**Tritax application re Hinckley National Rail Freight Interchange (HNRFI)**

**Interested Party Reference No. 20037843**

**1. Sapcote Village Centre**

**SAPCOTE ENHANCED
SCHEME
VISIBILITY TO
PEDESTRIAN CROSSINGS**

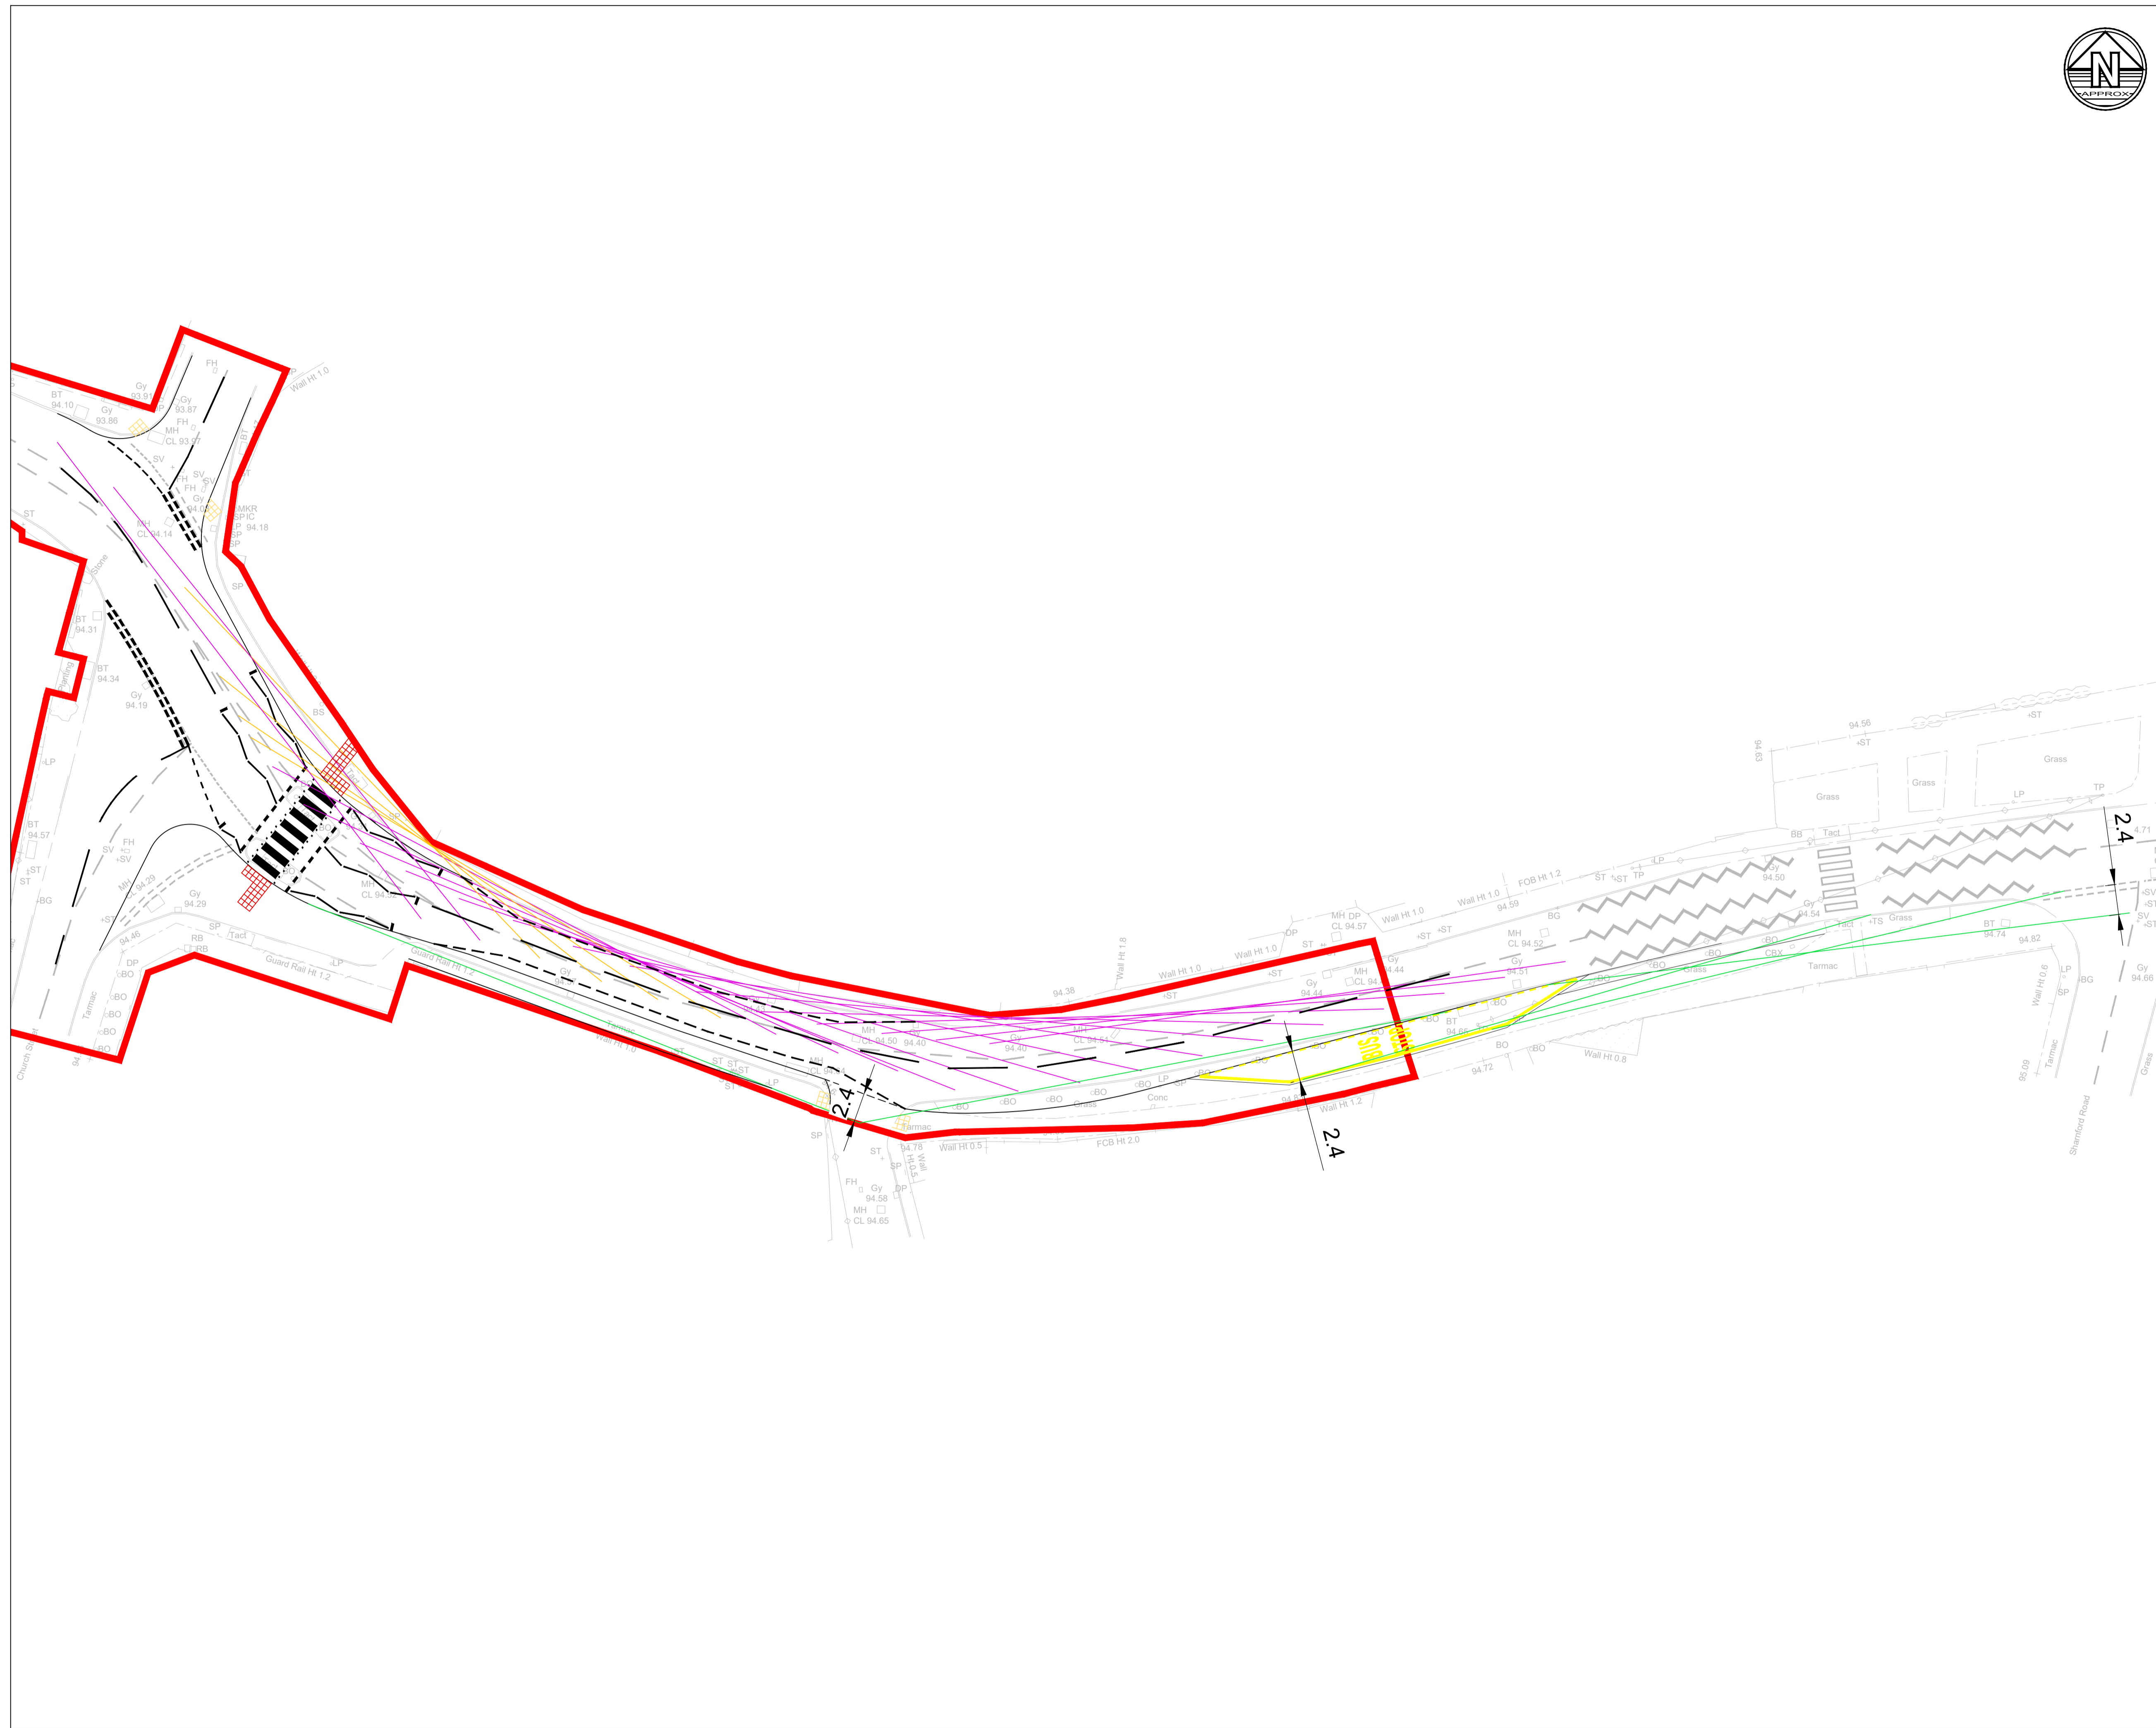
- h. It is difficult to see how the new informal crossing to the west of Stanton Road (Sapcote Technical Note Appendix C) would be used given that pedestrians crossing the B4669 to head towards the Co-op would then be faced with the very narrow walkway past the old horse mounting block outside Blacksmith's Cottage. It would be dangerous in the extreme to encourage pedestrians to use this walkway.
